20160433.2/1013/TT/R2

13 October 2017

Lindfield Learning Village – Response to Planning NSW and EPA Queries

Lindfield Learning Village - North (opposite Tubbs View): Tuesday 06 June, 2017

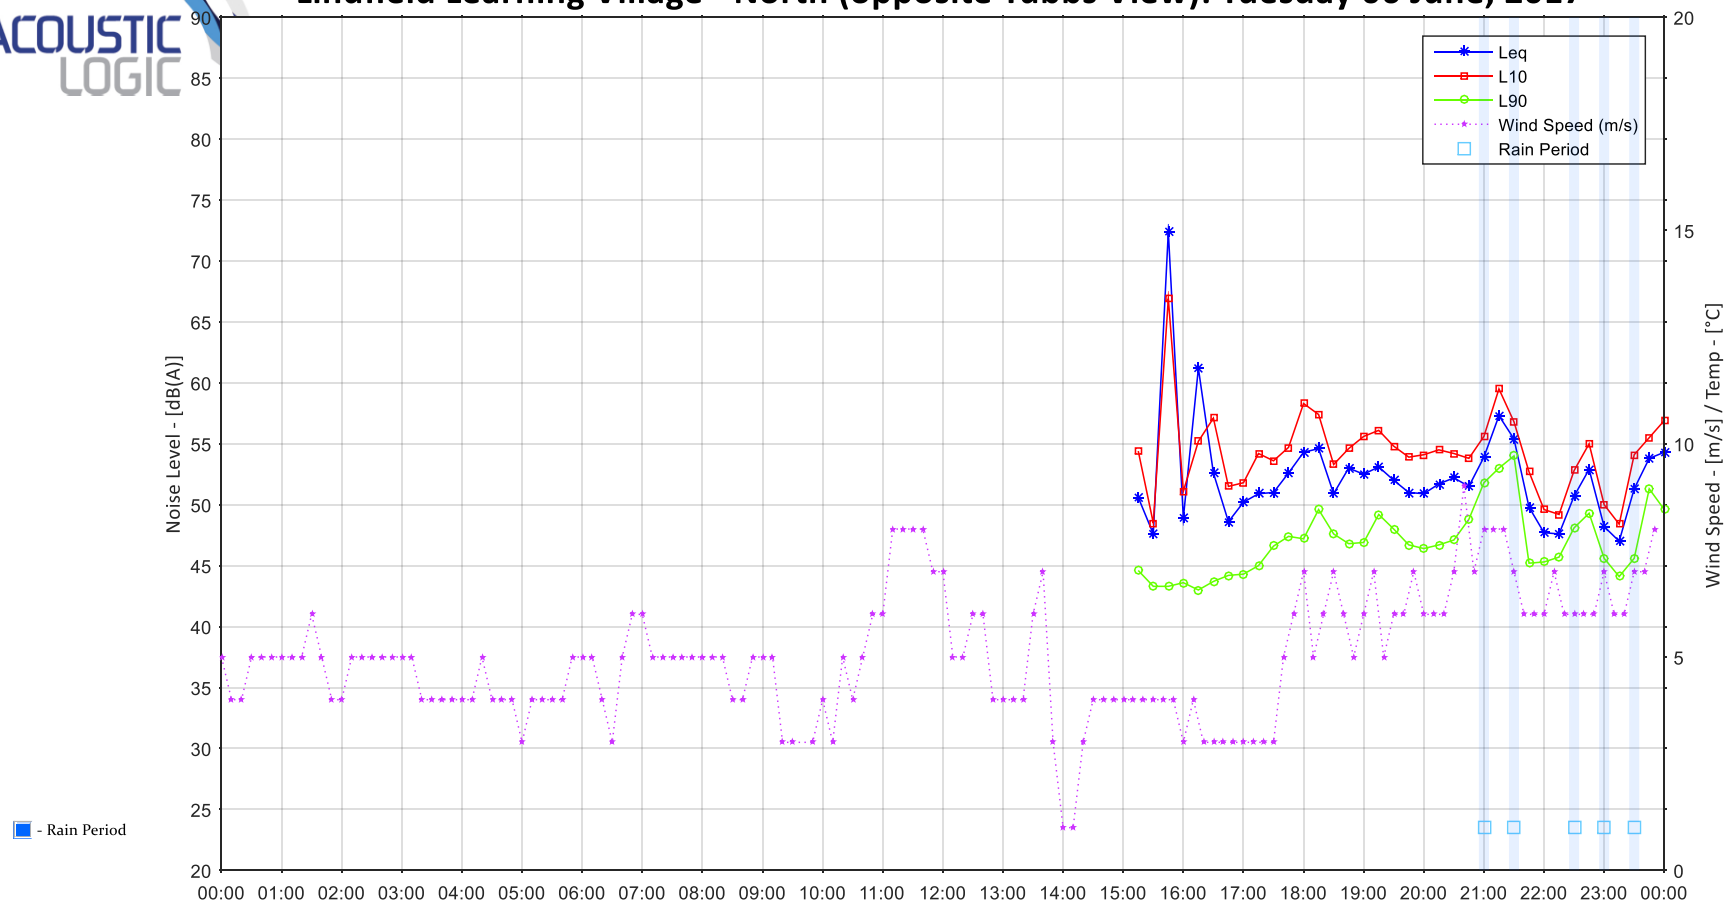
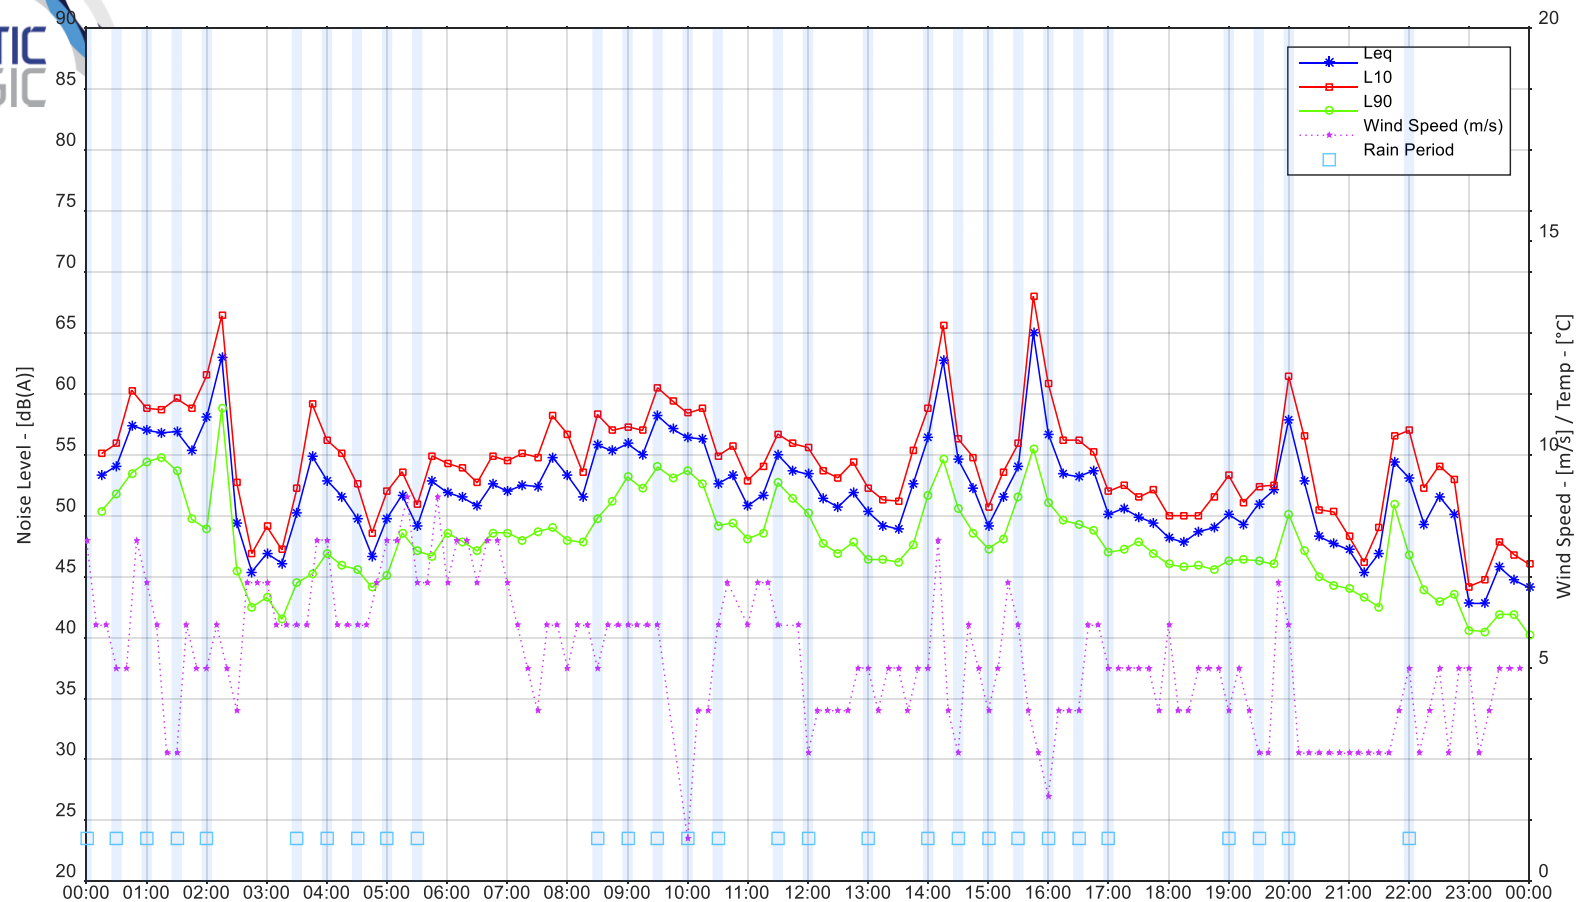
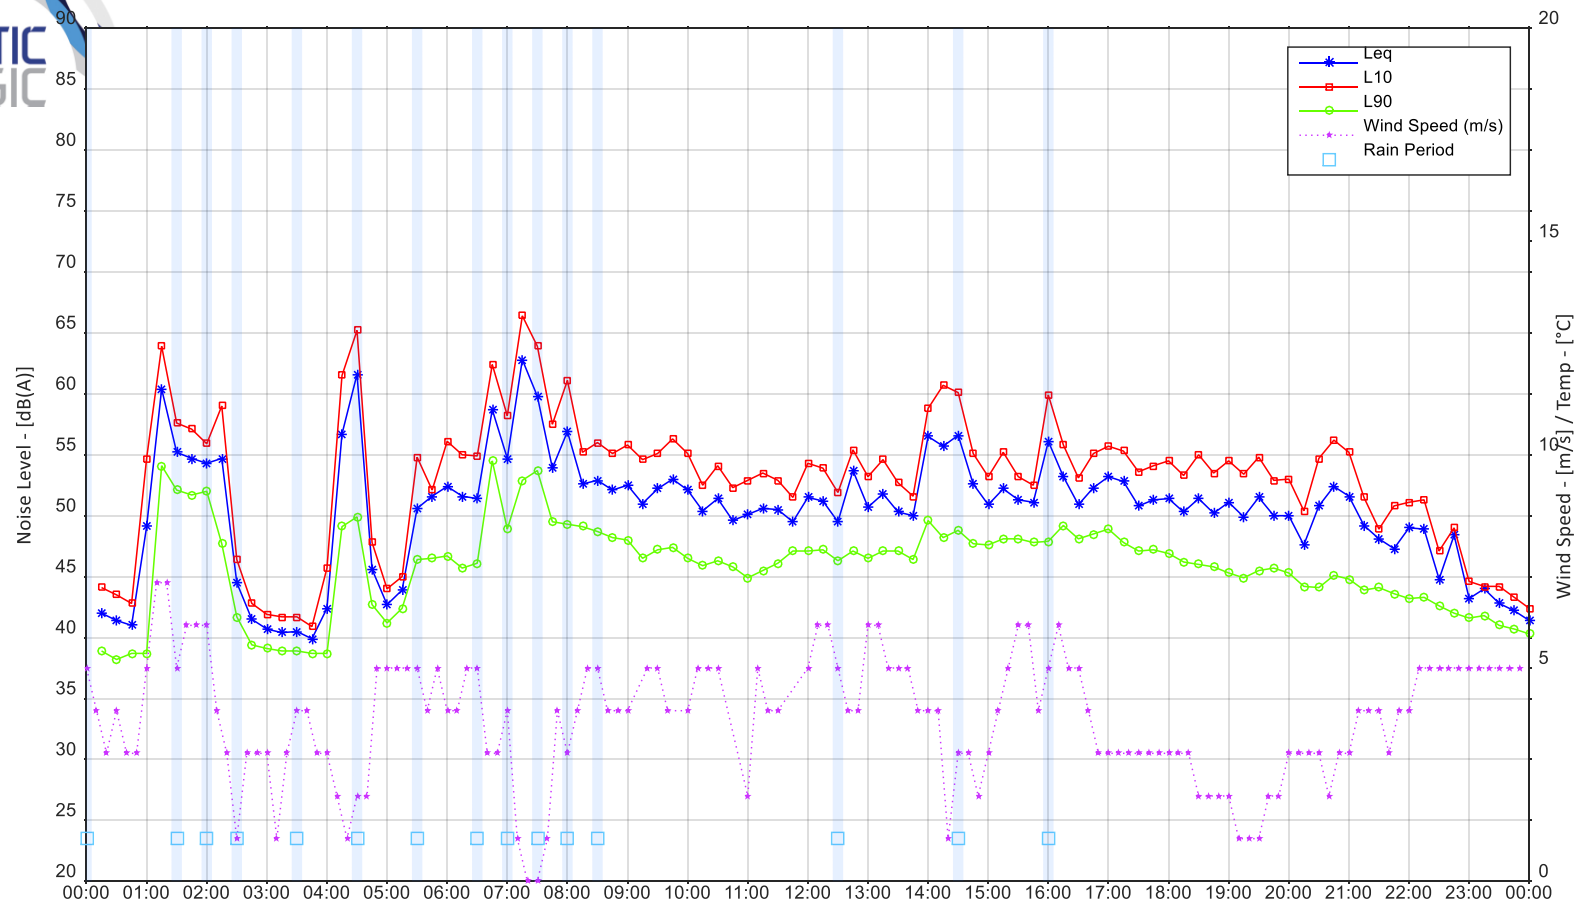
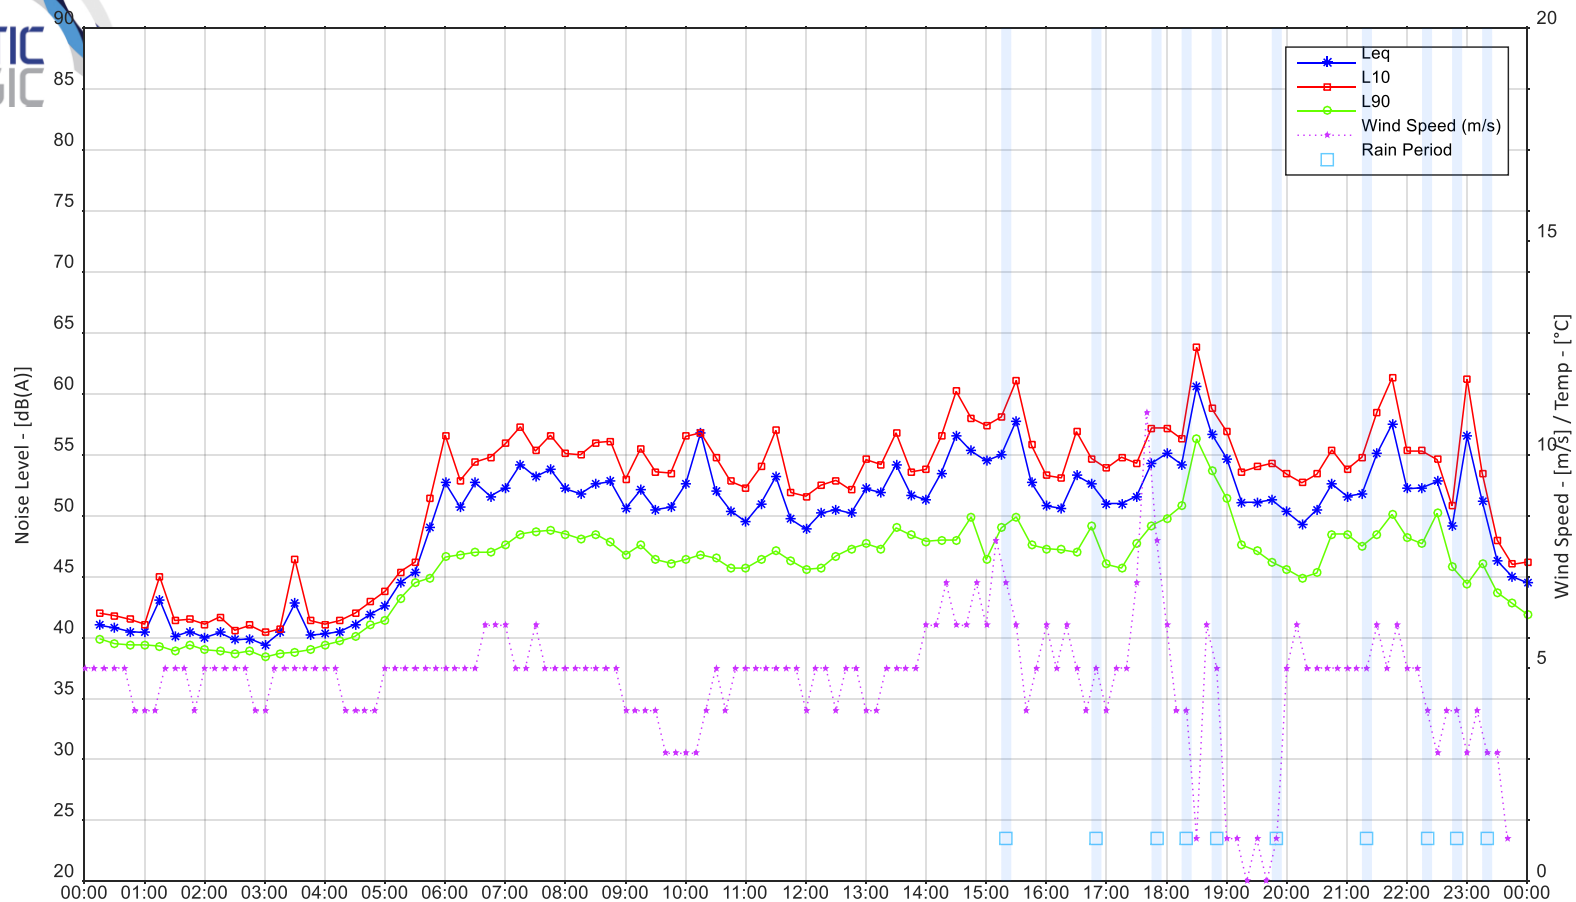
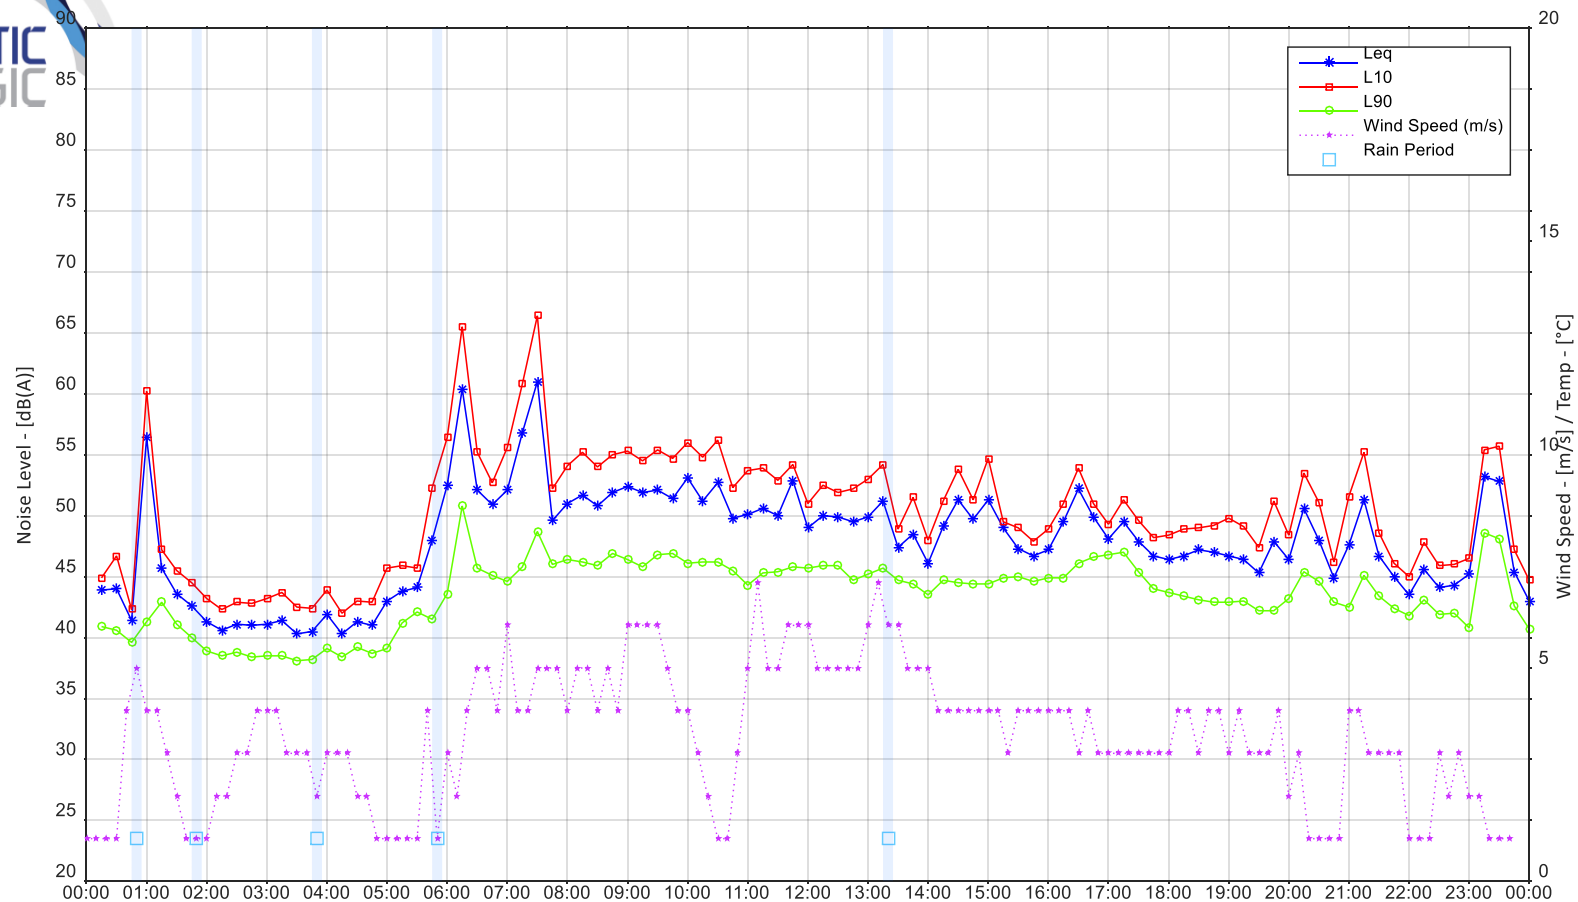
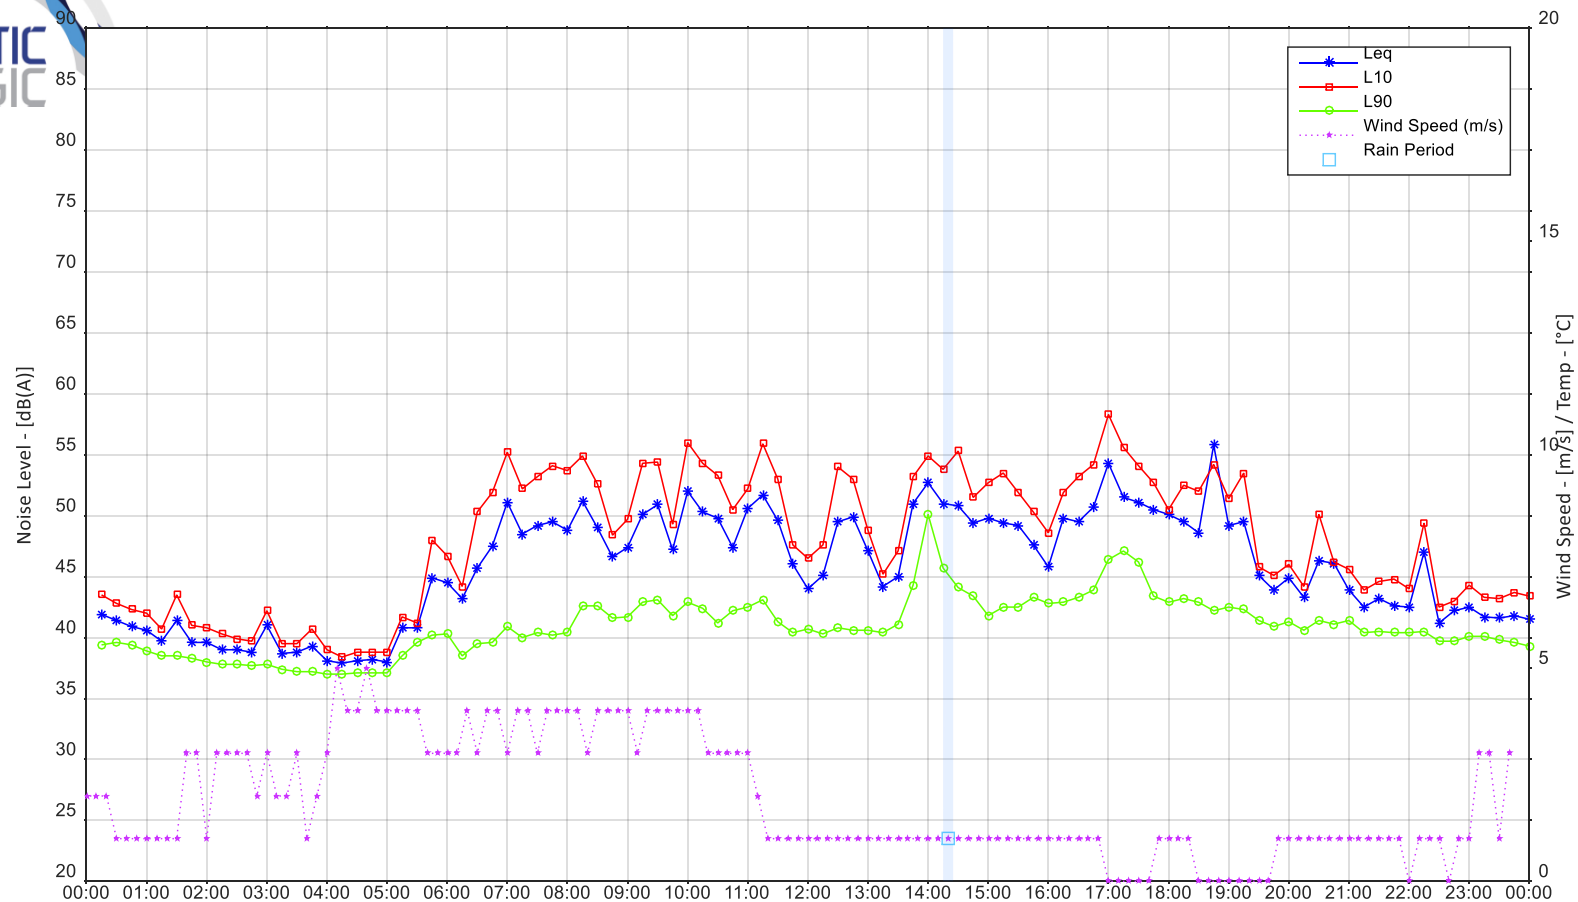
Planning NSW had queried the fact that a noise logger placed at the south of the site was also used to provide representative background noise levels for residences to the north of the site (Tubbs View).

We confirm that additional long term noise logging was conducted at the site near the Tubbs View residences in June 2017.

Logger location is shown in Figure 1 of our amended Noise Impact Assessment (Revision 5, dated 30/10/2017). The logger location was as close as practicable to the Tubbs View residences and is appropriate data for use when setting noise emission goals to these residences.

- Supplementary background noise logging was conducted at the north of the site (near Tubbs View, between 6 and 13 June) which is not affected by filming noise.
